**Application No:** 19/00213/DISC-4

**Proposal:** Discharge of conditions 6 (new link road), 8 (surface water drainage), 9 (floor levels), 10 (play areas), 11 (arboricultural survey), 12 (ecology), 13 (secured by design), 14 (contamination), 18 (mitigation for badgers) and 35 (cycle lanes) of 15/01326/OUT

**Location:** West Of Cricket Field Nor Wykham Lane Bodicote

## **Lead Local Flood Authority**

Swale 1

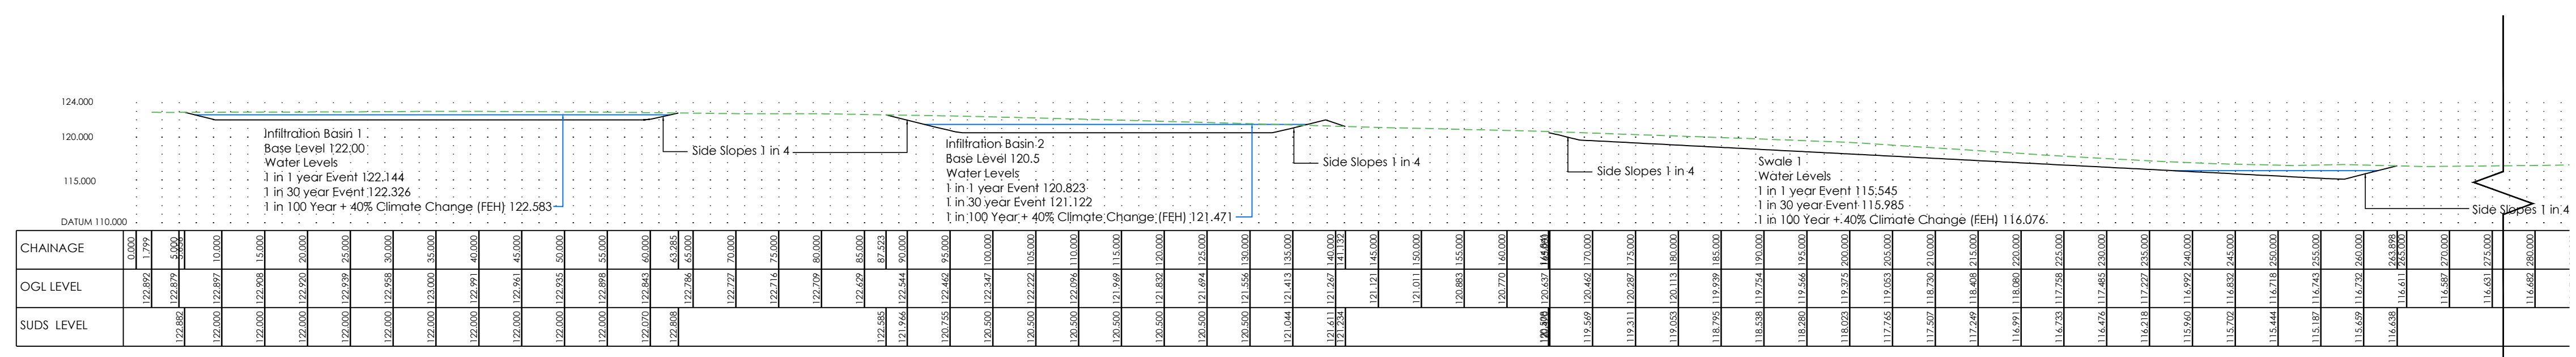
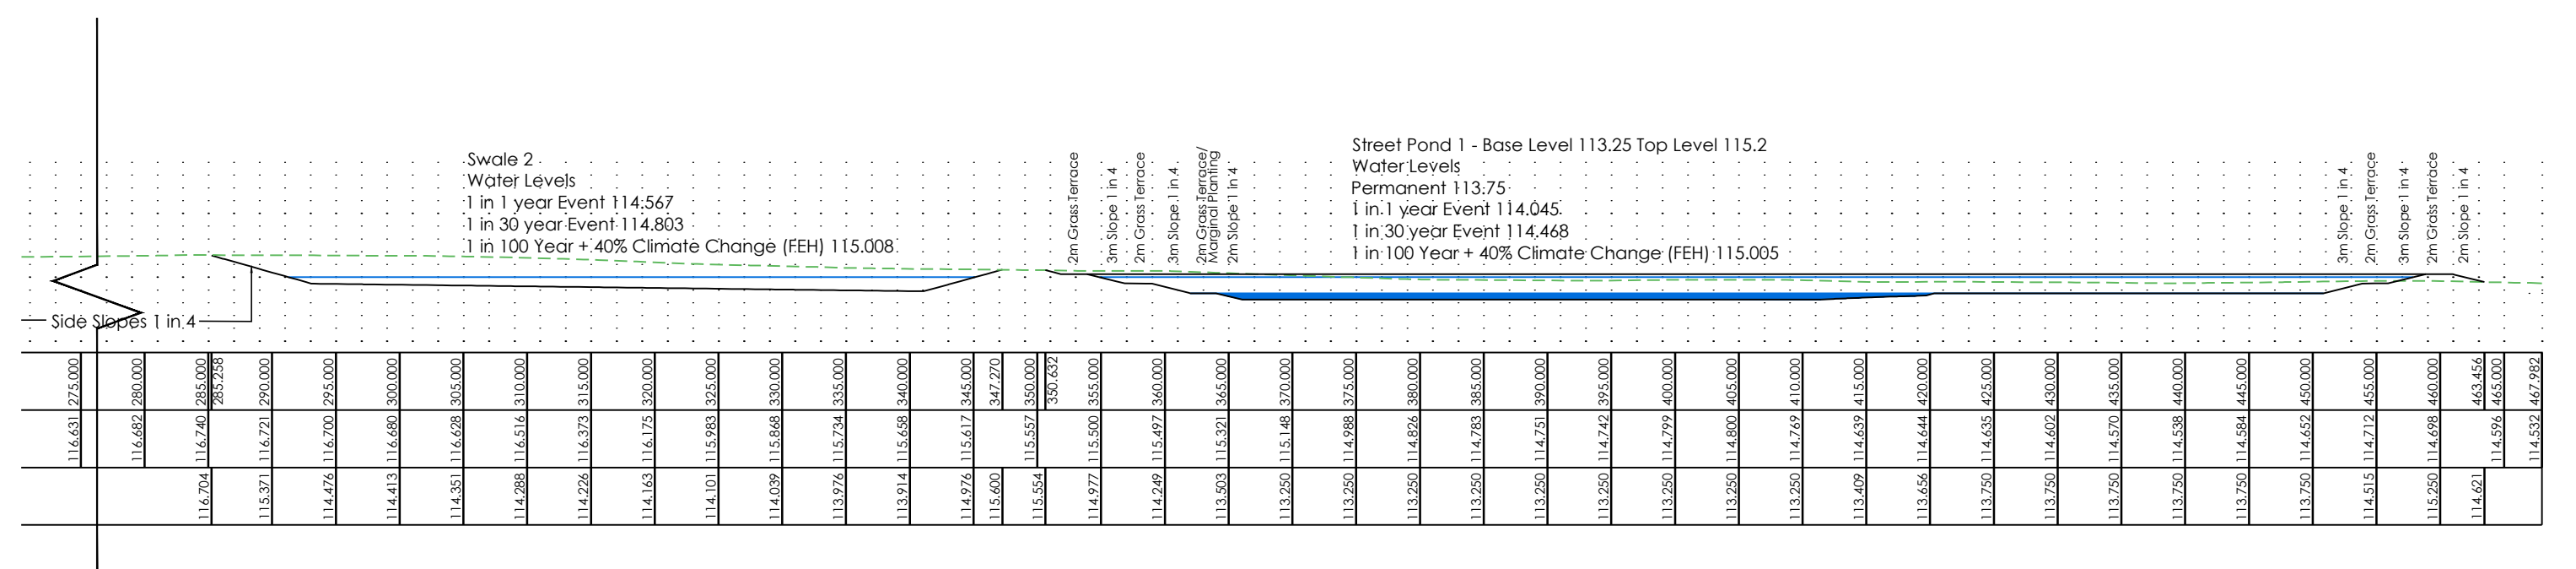
1. Detailed design drainage layout drawings of the SuDS proposals including cross section details;
2. Detailed maintenance management plan in accordance with Section 32 of CIRIA C753 including maintenance schedules for each drainage element; and

6. It has also been noted that half-drain down times have not been achieved for some attenuation features. Therefore, the design is not conforming to Standards.

TITLE: **Adoptable Drainage**

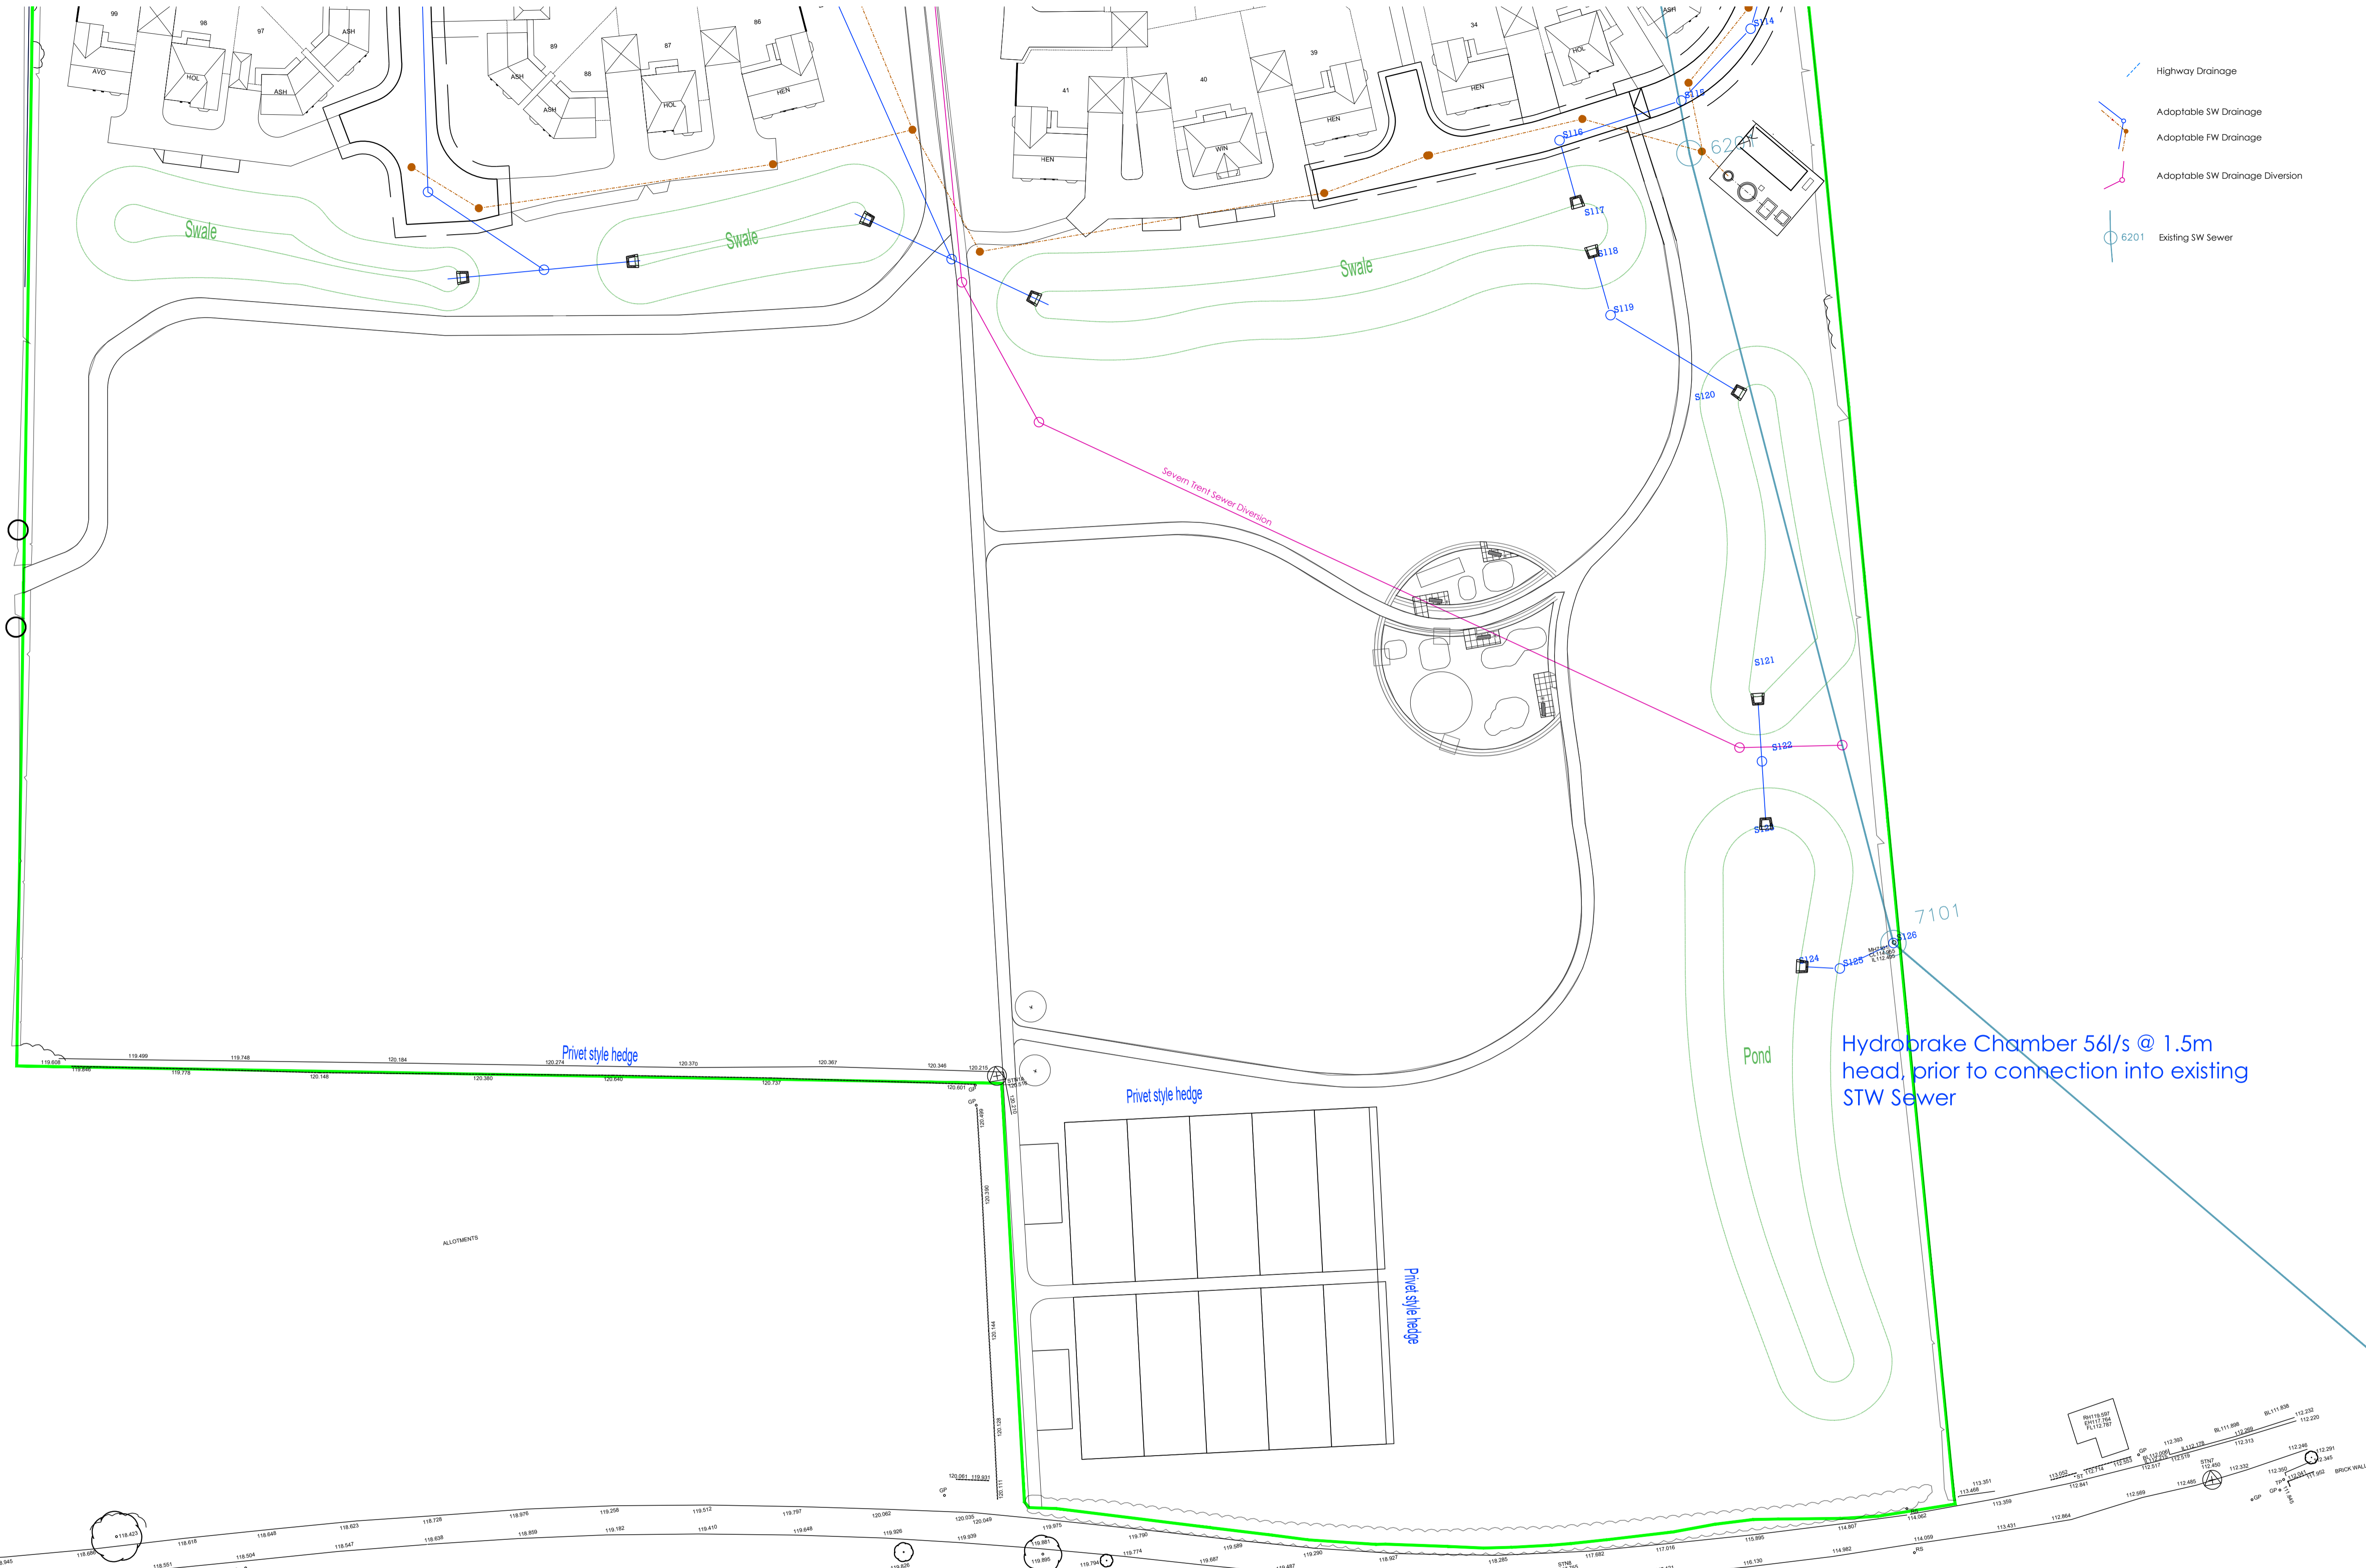
3. Details of how water quality will be maintained during construction.
4. The discharge rate must be agreed with the LLFA not Thames Water. An updated detailed drawing indicating final point of discharge and rate to be provided for technical assessment. The LLFA currently believe the discharge rate is not reflective of the required greenfield rate. The LLFA require justification for the use of 56l/s discharge rate.
